Item No. **Report of the Head of Planning, Transportation and Regeneration**

Address 29 PARKFIELD ROAD ICKENHAM

Development: Erection of a replacement dwellinghouse with associated car parking and landscaping, following demolition of the existing bungalow

LBH Ref Nos: **14459/APP/2021/1343**

SITE PLAN
1:500

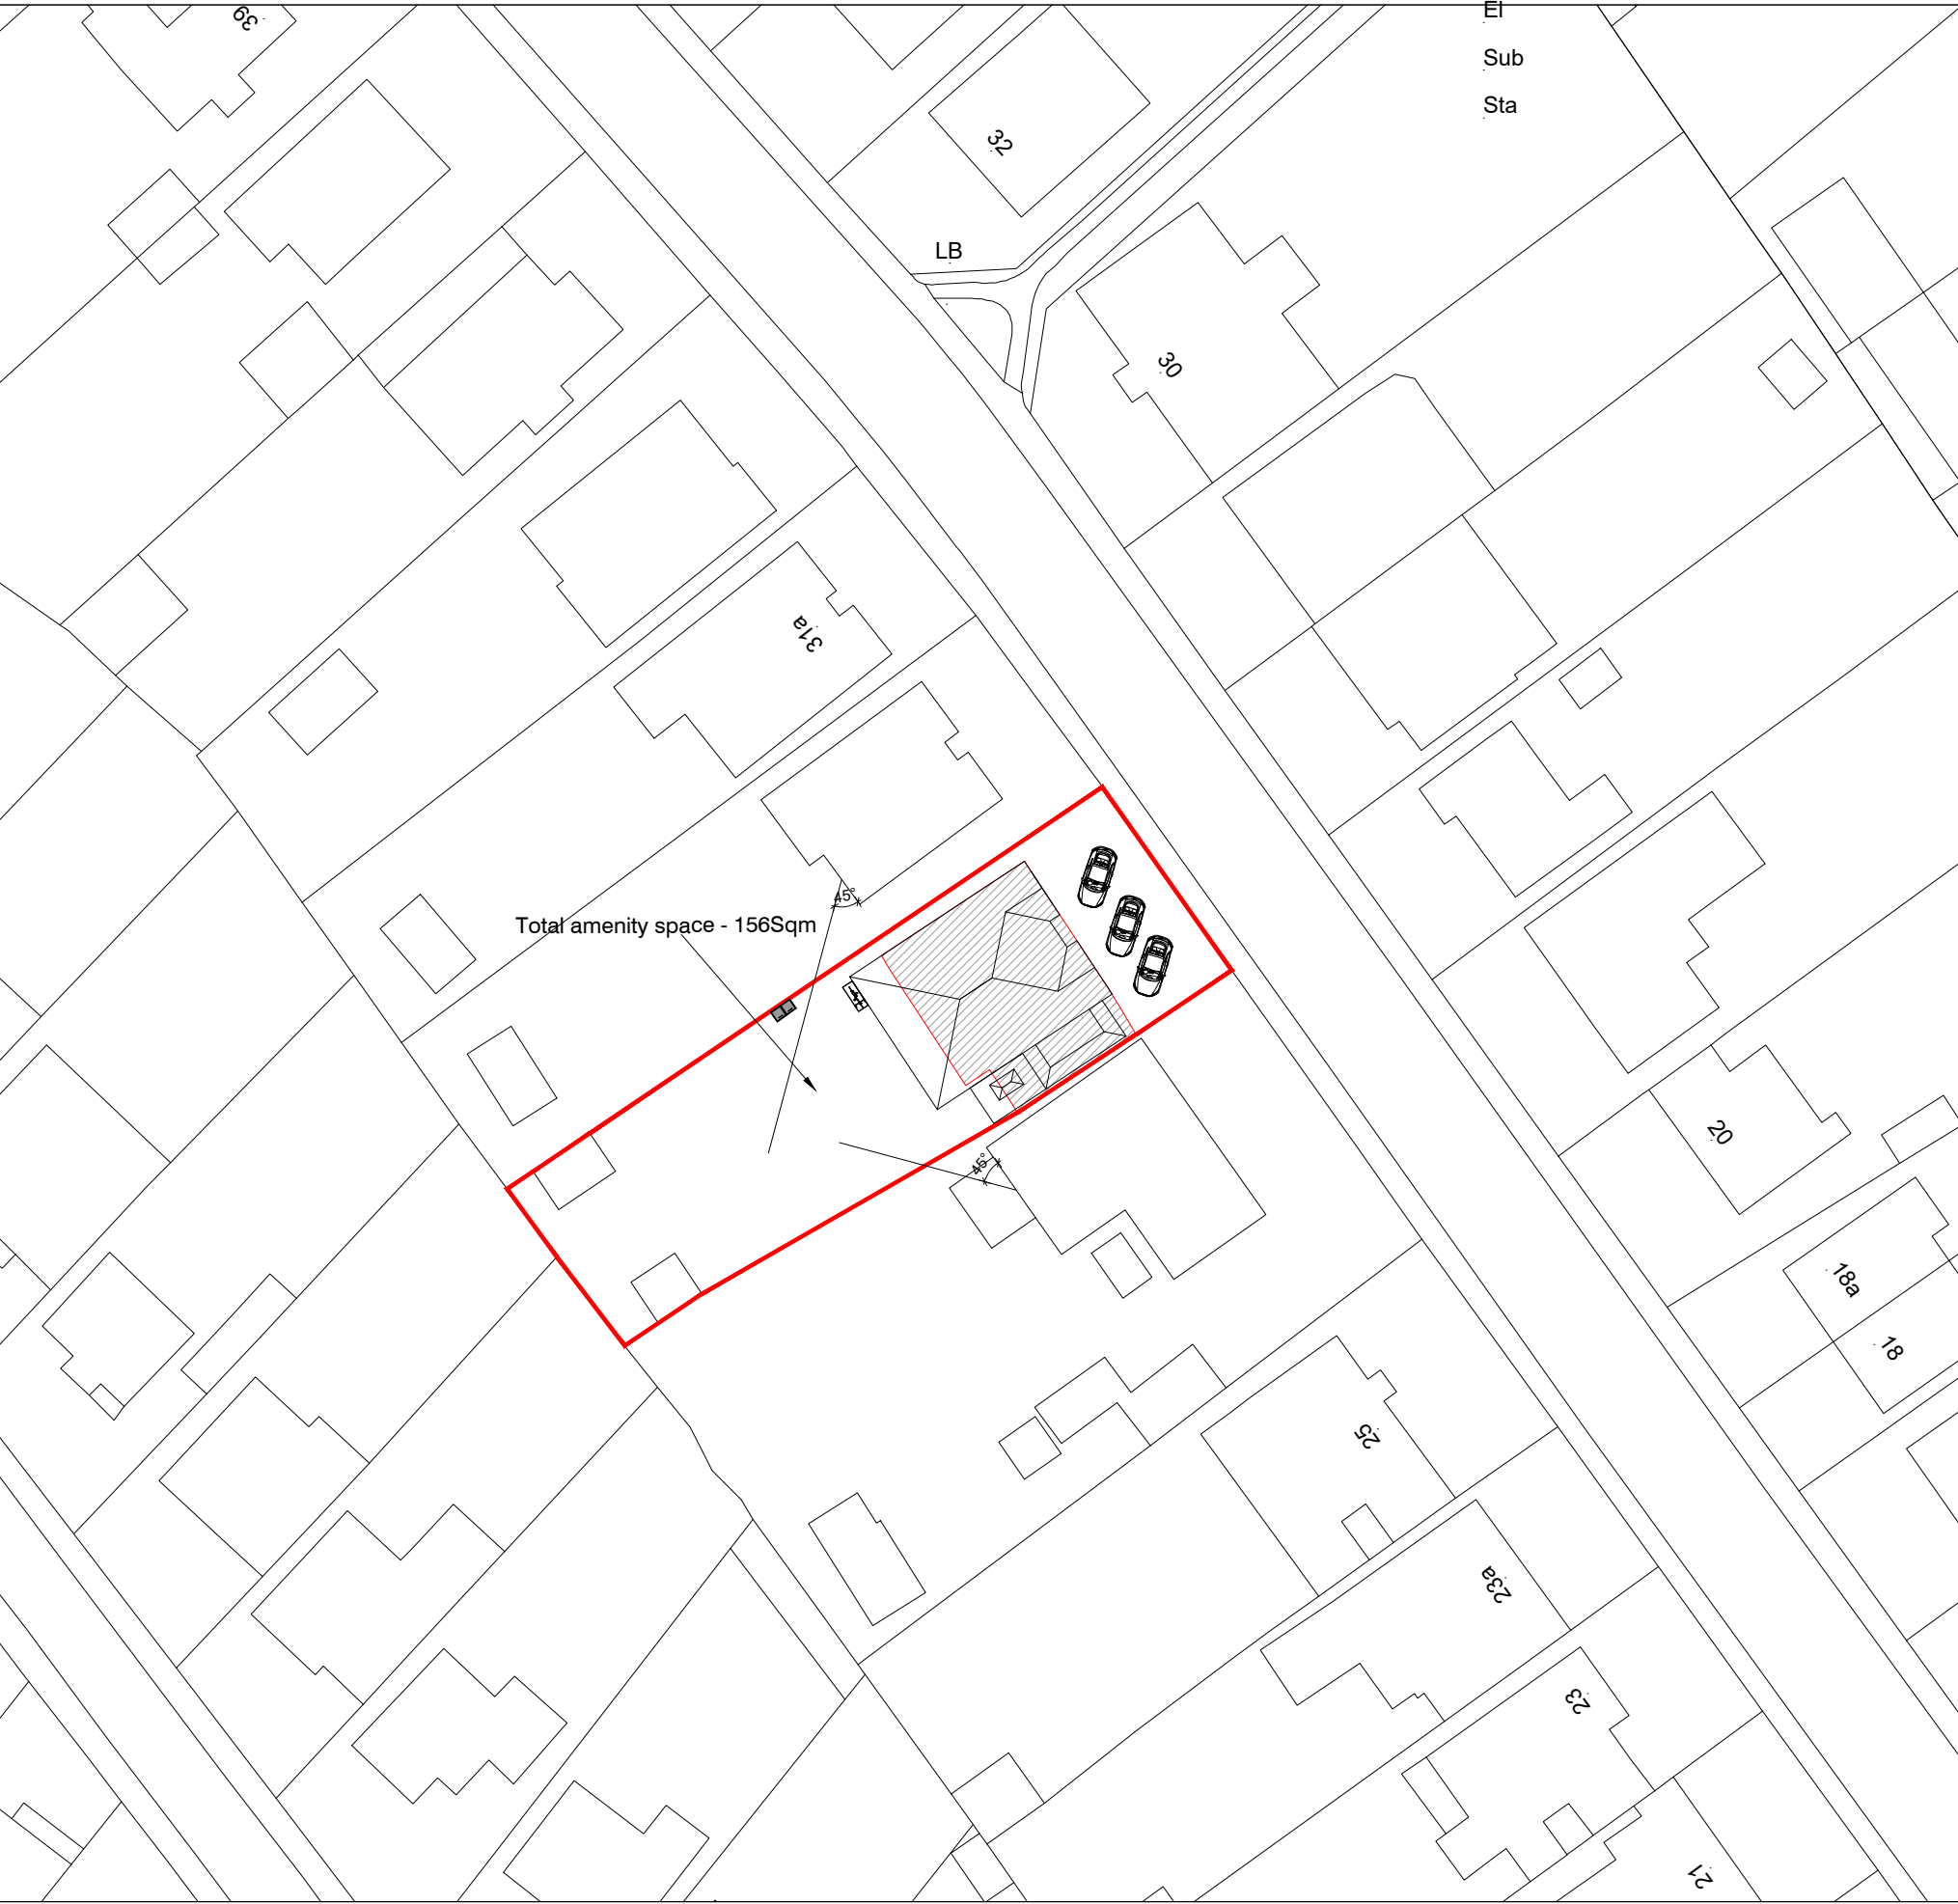
COMMENT: No trees will be affected by the proposed footprint of the building, however, the expansion of the driveway will lead to the removal of established vegetation which is indicated to be replaced by very small meaningless planting pockets. Ideally the existing planting should be protected retained or, at least, replaced with reasonable areas of soft landscape along the front boundary.

The local plan maximum car parking standard requires up to 2 spaces to be provided on-site. It is noted that the site plan makes reference to car parking for three cars. Notwithstanding the proposed plans, should the application be considered acceptable, a landscaping condition is required to provide details of soft landscaping and front boundary treatment to ensure the property continues to contribute to the streetscene and provides only up to 2 car parking spaces in line with Policy DMT 6 of the Local Plan: Part Two (2020).

indicated to be replaced by areas of planting. The revised plans illustrate more generous planting within the front garden which is considered appropriate. Should the application be considered acceptable, details of tree protection and hard and soft landscaping would be required by condition.

PROPOSED FRONT ELEVATION
1:100

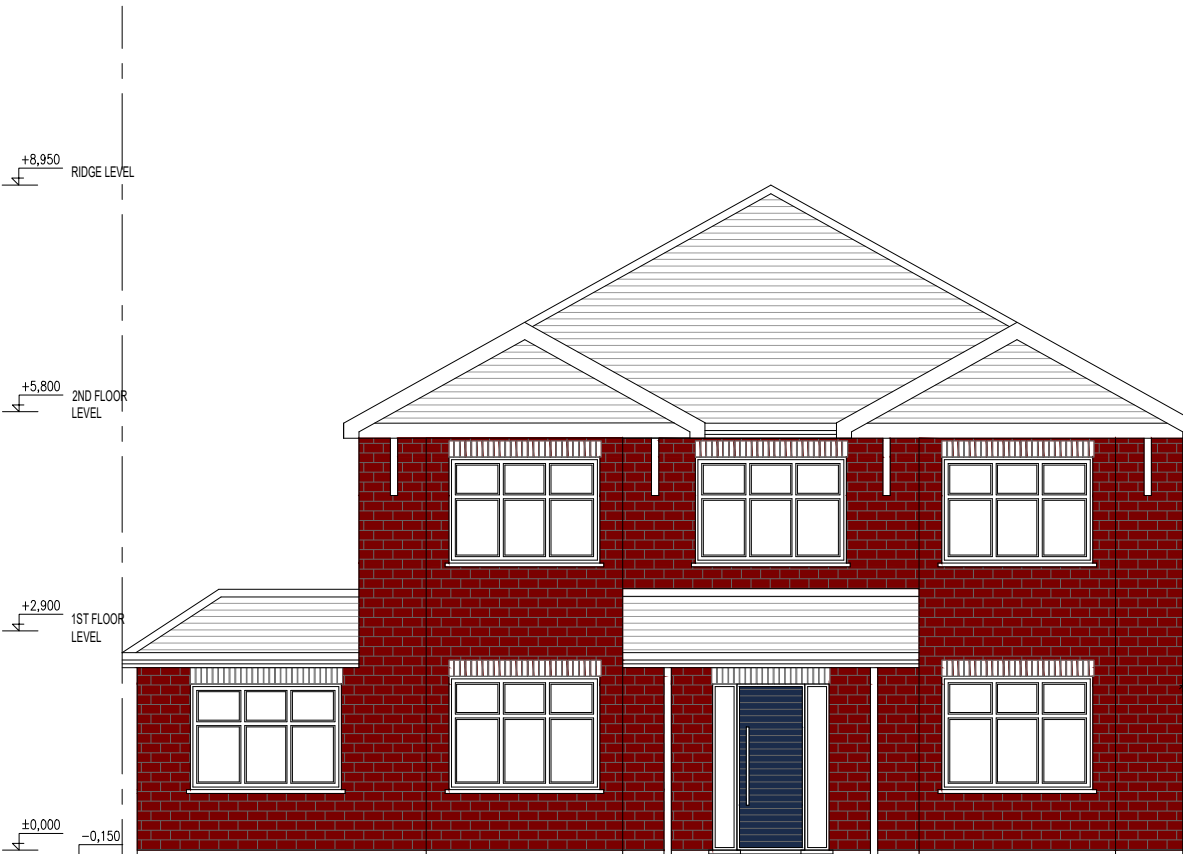
The application proposal would be set in from the boundary with No. 31 Parkfield Road by 1m with a single storey element adjoining the boundary with No. 27 Parkfield Road. The proposed dwelling would measure upto 14.3m in depth, 8.1m in height and 14m in width. Whilst it is acknowledged that Parkfield Road is of a varied character, the south east of Parkfield Road is characterised by bungalows. The 3 properties immediately to the north of the application site comprise of part 1.5 storey, part 2-storey properties forming a distinctive pattern of development along this part of Parkfield Road.

The proposal seeks to provide a 2-storey building with double fronted bays. Whilst the front building line is consistent with the adjoining properties, its scale, width and depth is larger. As a result of the applicant's attempts to reduce the height of the building, the latest amended plan submitted by the agent on 21-05-2021 includes a crown roof which exacerbates the bulkiness of the building. The materials include red brick, roof tiles and white UPVC framed windows on the front elevation.

Whilst the wider streetscene of Parkfield Road is characterised by a variety of architectural styles, this part of Parkfield Road comprises a distinct pattern of development and within this context, the replacement dwellinghouse due to its size, scale and design fails to transition appropriately between the bungalow at No. 27 and the property at No. 31. The proposed development has failed to have regard to the local context and fails to harmonise with the local context.

amended plans made alterations to the height of the dwellinghouse, however the alterations do not overcome the objections set out above. The pre-application advice was taken into account in coming to a decision, however following a detailed review of the proposal, a review of the plan illustrating the proposal within the streetscene and the neighbouring objections, the proposal is considered inappropriate.
